**SSD 8636: ENGINEERING & TECHNOLOGY PRECINCT DEVELOPMENT  
UNIVERSITY OF SYDNEY, DARLINGTON CAMPUS**

**UNIVERSITY OF SYDNEY RESPONSE TO SUBMISSIONS 2**

**9 DECEMBER 2018**

Project
THE UNIVERSITY OF SYDNEY ETP STAGE 1
Electrical Engineering Building
University in Darlingtown, NSW 2008
Drawing Title
FLOOR PLAN - LEVEL 02

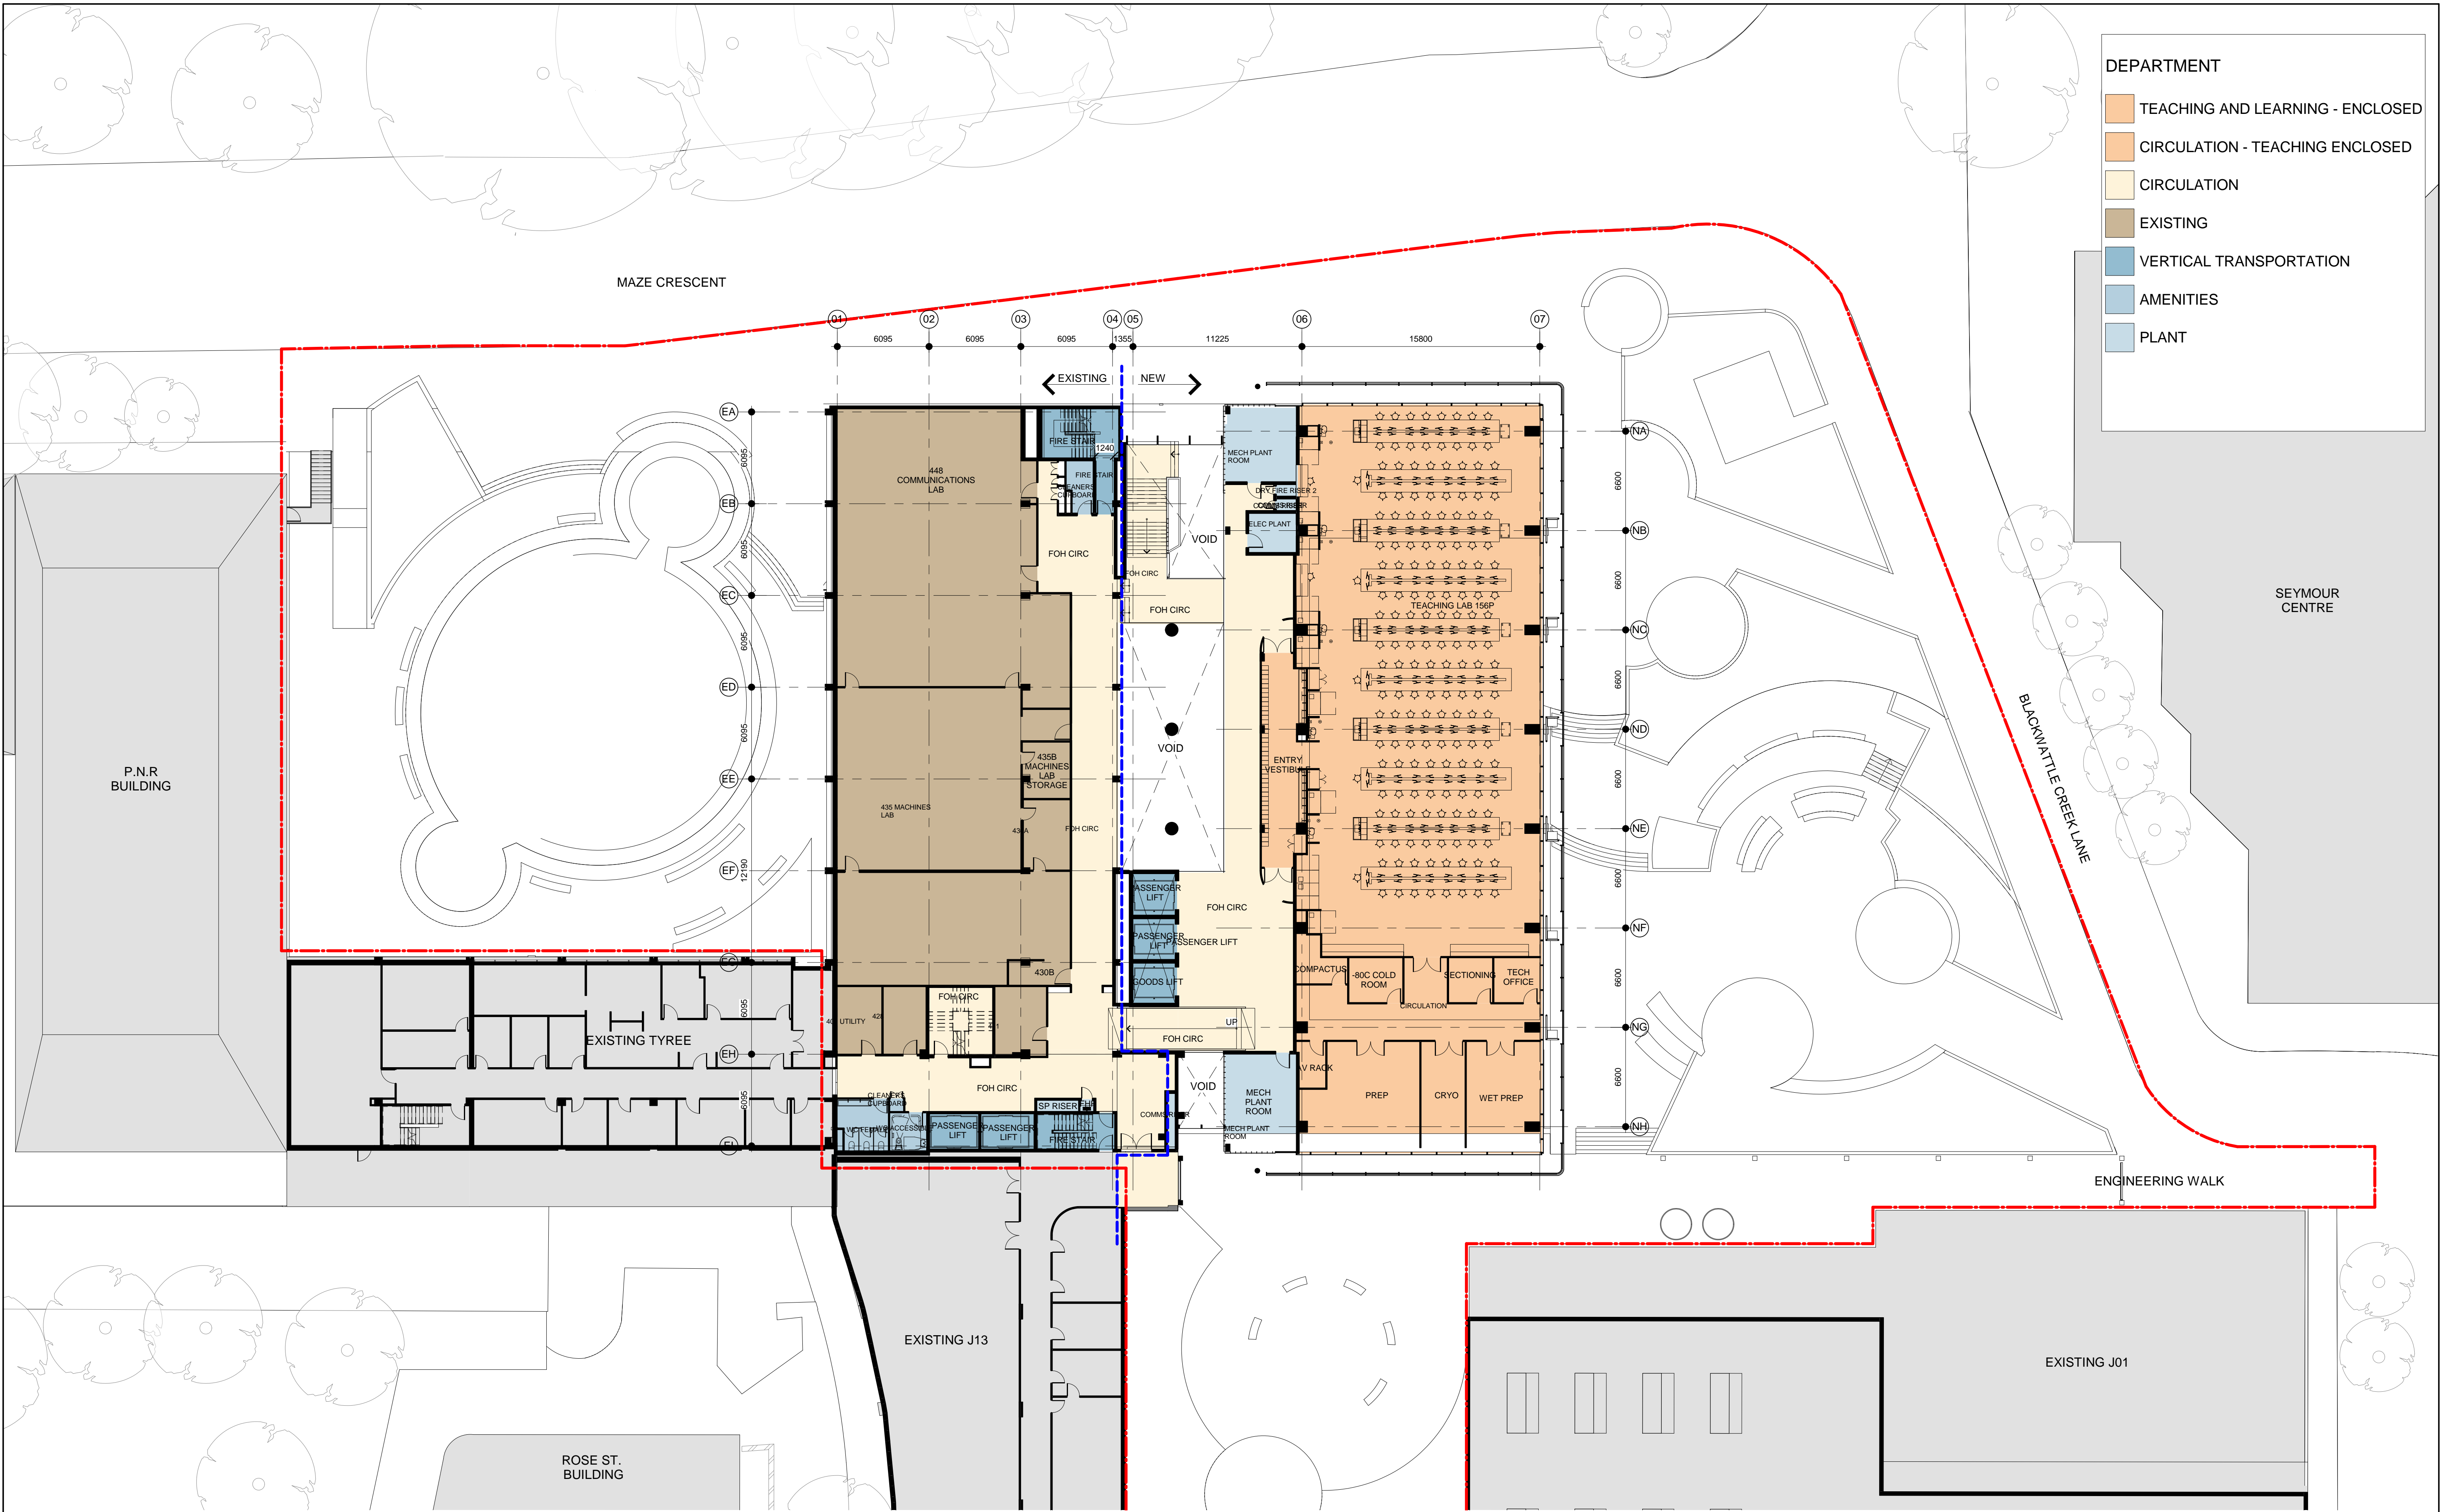
7. With respect to bicycle parking, the proponent's response states that bicycle parking provision has been calculated and provided in accordance with Sydney DCP 2012, which is demonstrated on the Level 2 floor plan of the revised architectural drawings. The referenced plan provides no evidence in this regard. The Department are requested to include a condition that specifically requires bicycle parking provision and end of trip facilities to be provided by the development that comply with Section 3.11 of Sydney Development Control Plan 2012.

The ETP project is an alteration and addition to an existing building. The net population uplift has been calculated by subtracting the existing building population from the new building population. It is noted that the proposed new building is not designed to accommodate a significant increase of staff/student population to the Engineering precinct or Darlington campus. A small increase is envisaged by the proposed development as referred to below.

Notwithstanding this, the end of trip facilities currently planned for this development provide for 48 Bike spaces, 5 showers and 48 lockers (subject to design development) which is in excess of the minimum required by Section 3.11 of *Sydney Development Control Plan 2012*.
